Planning Application No: 3/2025/0300

Proposal: Proposed replacement windows, additional Velux windows, adjustment to four window openings, provision of pigeon hole vents to gable wall. Glazed link to and conversion of garage to art studio, including timber cladding, infilling of door and replacement of vehicular door. Installation of Air Source Heat Pumps.

Location: The Barn, Preston Road, Longridge PR3 3BL

Planning Application
Proposed Site Plan

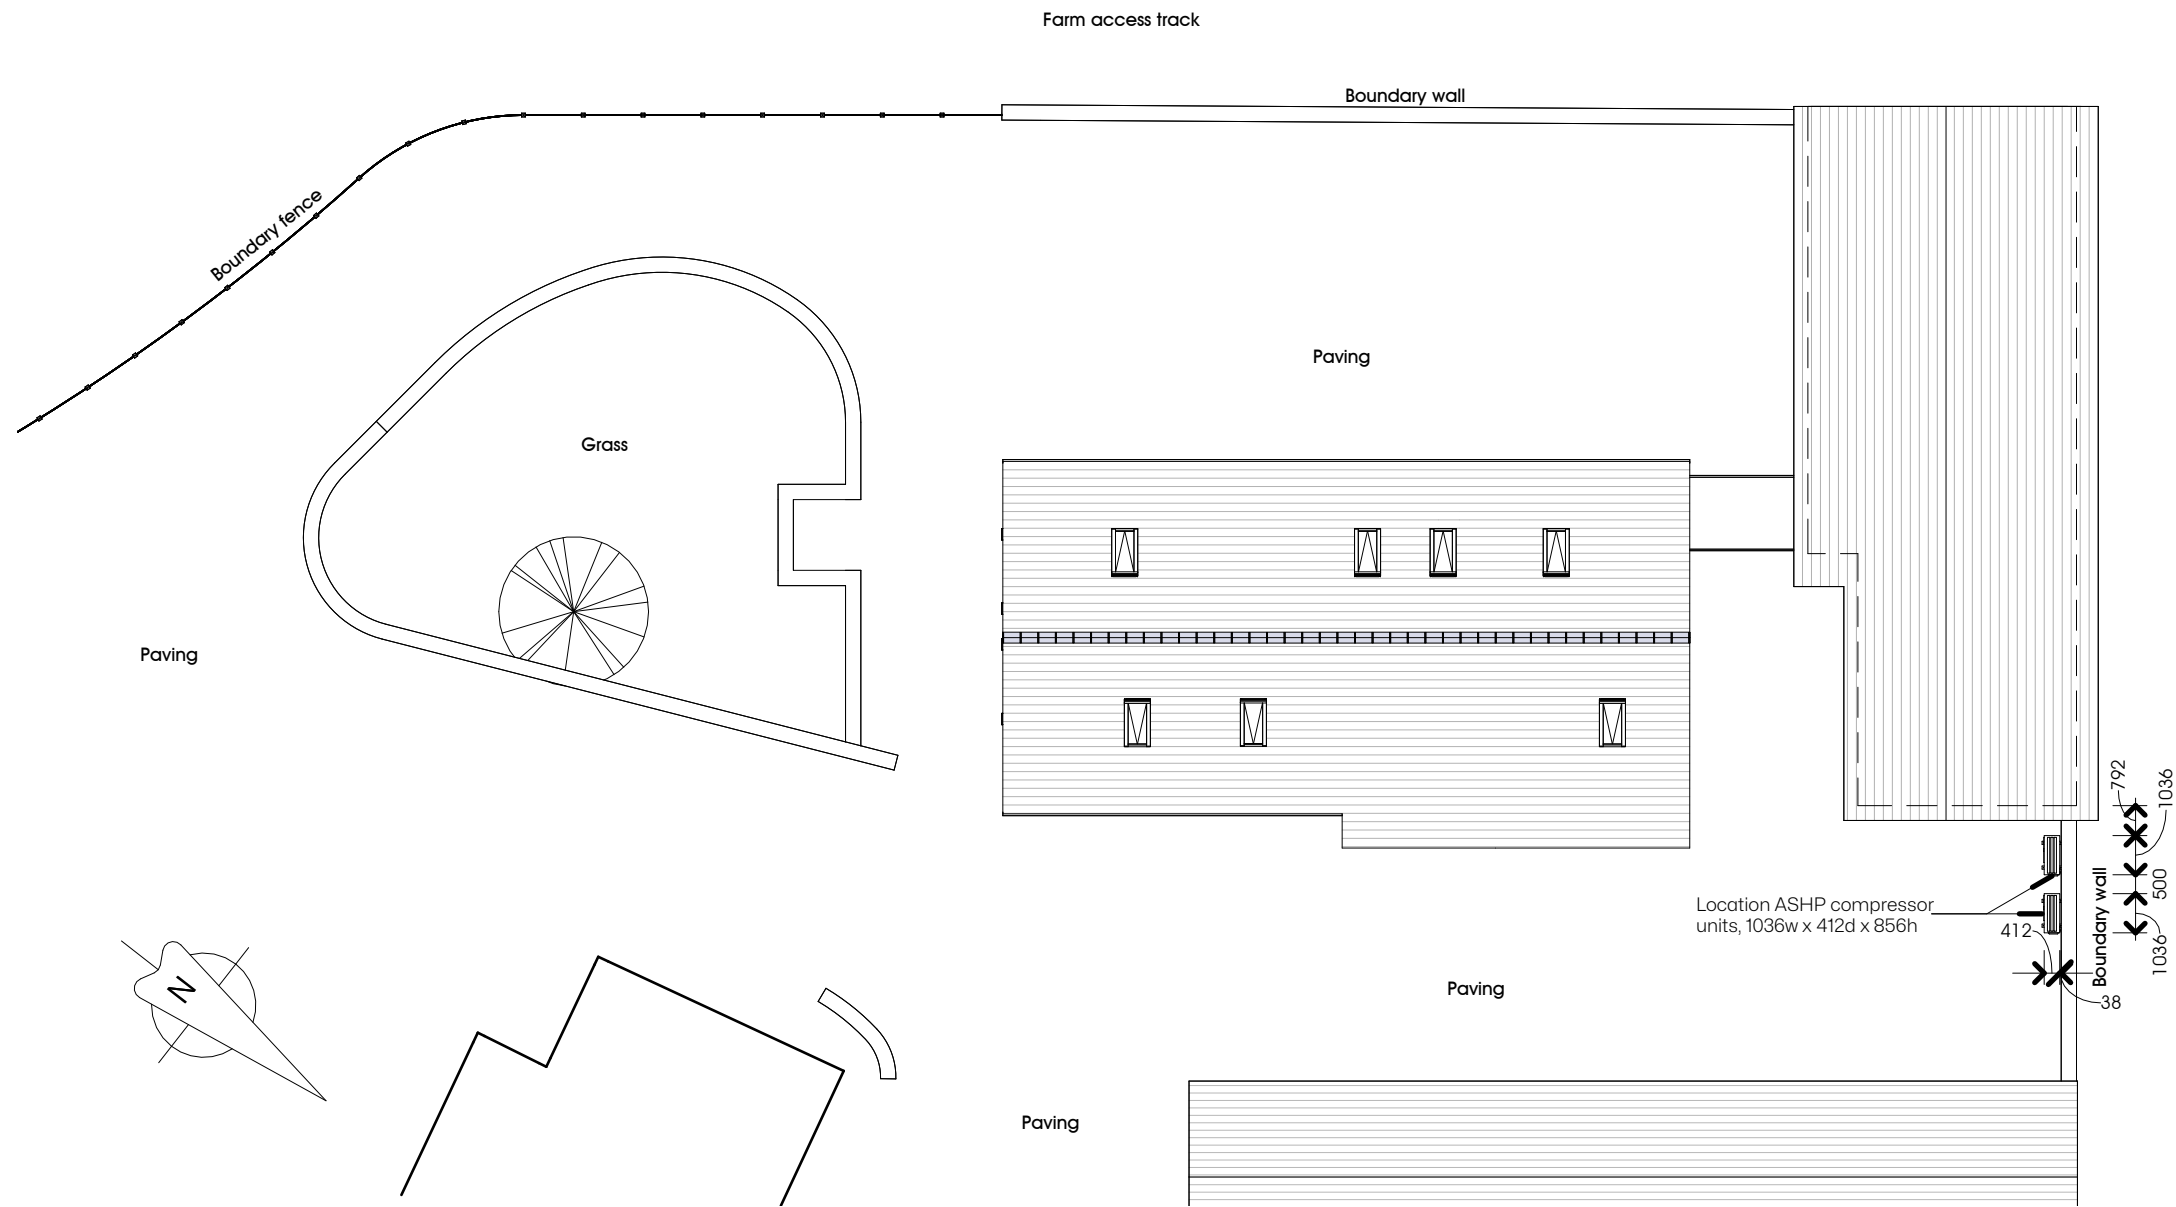
There are currently two detached garages on site – one double and one single garage. The double garage will be lost to the conversion to an art studio with the resultant loss of two car parking spaces. The single garage will continue to provide one car parking space and is also adequately sized internally to provide secure cycle storage and an electric vehicle charging point.

The highway authority considers that two car parking spaces should be provided for a dwelling with three bedrooms. One can be provided in the retained single garage with room for at least one further space within the curtilage. However, to ensure that adequate parking and manoeuvring is retained the highway authority recommends that the use of the studio is restricted to personal use only.

The studio hereby approved shall only be used for the personal use of the existing dwelling and shall not be used for any commercial purpose which may generate additional traffic and vehicle movements which have not been assessed. Reason: To ensure that adequate parking and manoeuvring provision are retained on site.
